Application No: EP/124/20/HH
Site Address: Little Dormers 23 Upper Drive East Preston BN16 1QN
Description of works: New bay and porch skirt roof to the front elevation, and roof linked detached double garage.

Thank you for your internet representation made on 16th November 2020 which has been recorded as an objection with the comments as follows:

Garage Plans and Elevations -
Proposed

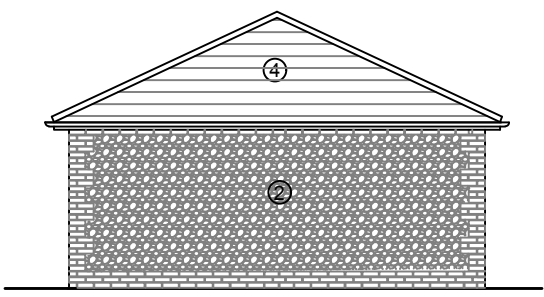
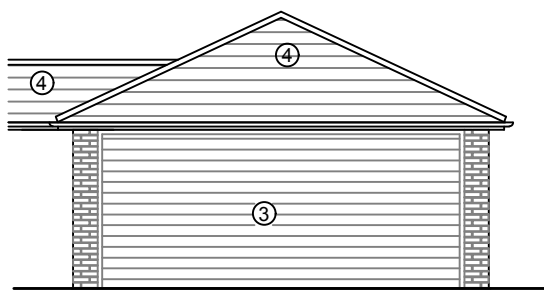
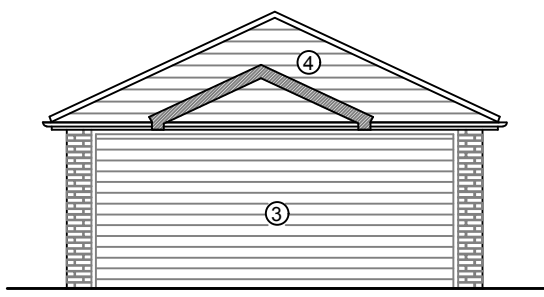
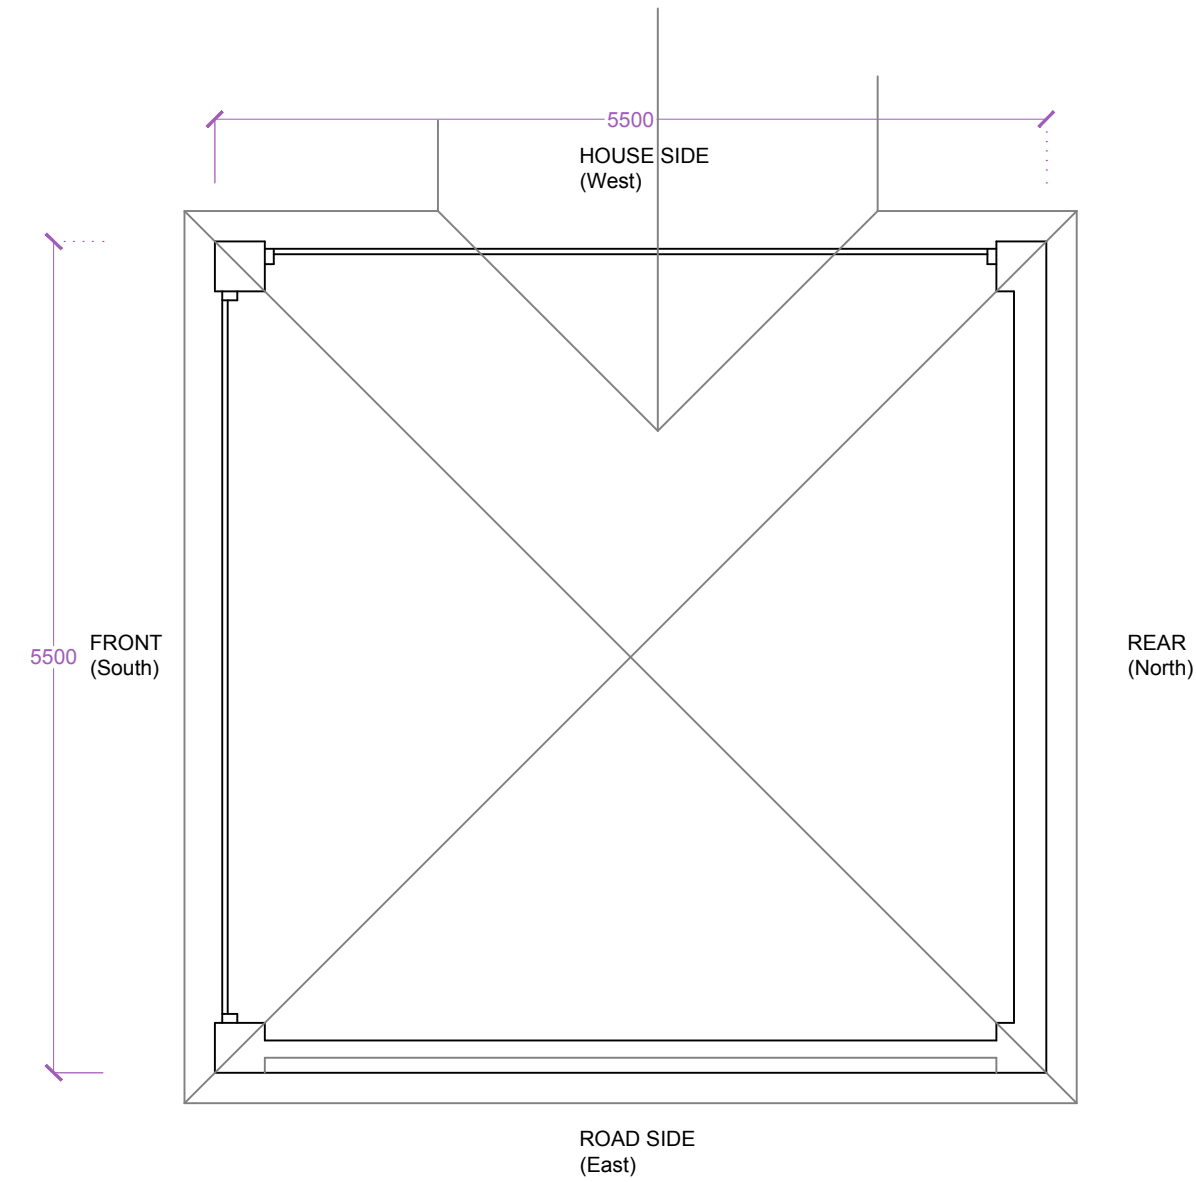
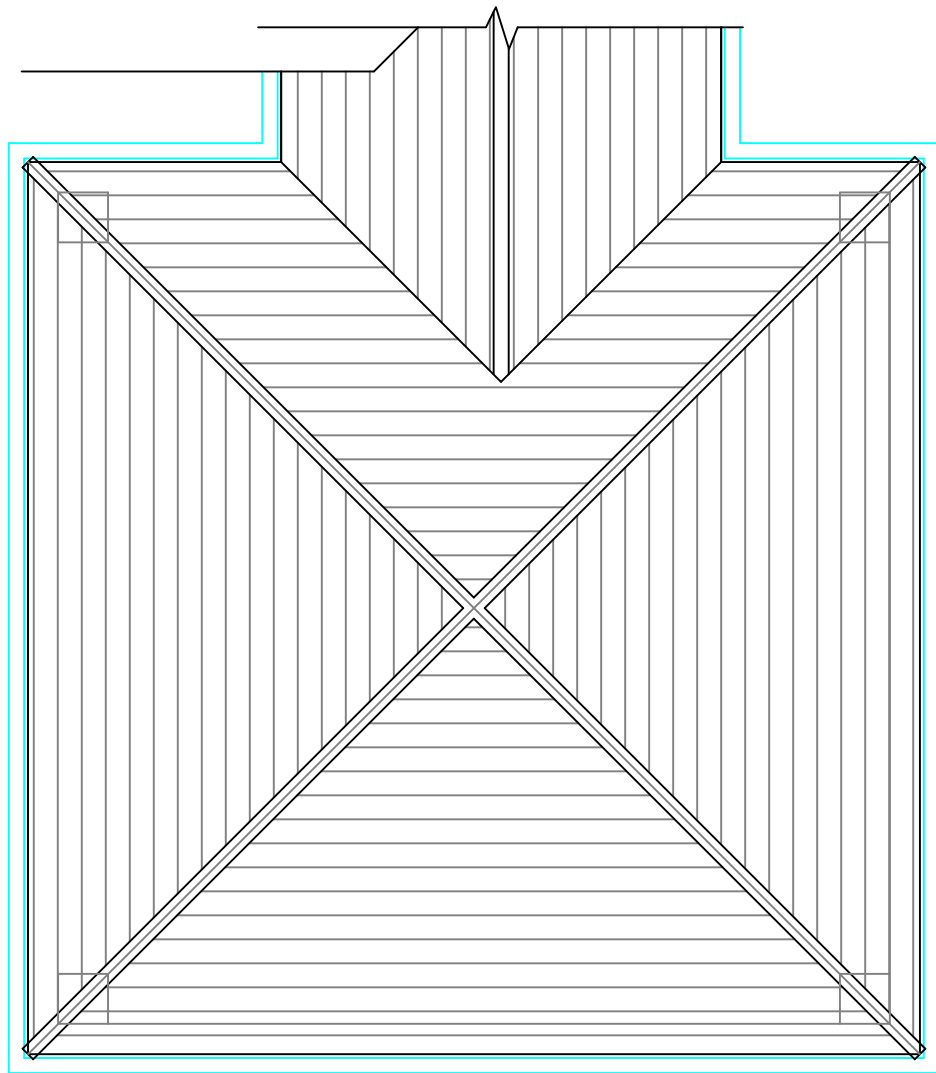
WE consider this proposed double garage not only unsightly but far to large. It will look hideous and far exceeds the building line of surrounding properties. As it is on the boundary with no25 it will blockout considerable sunlight and views.
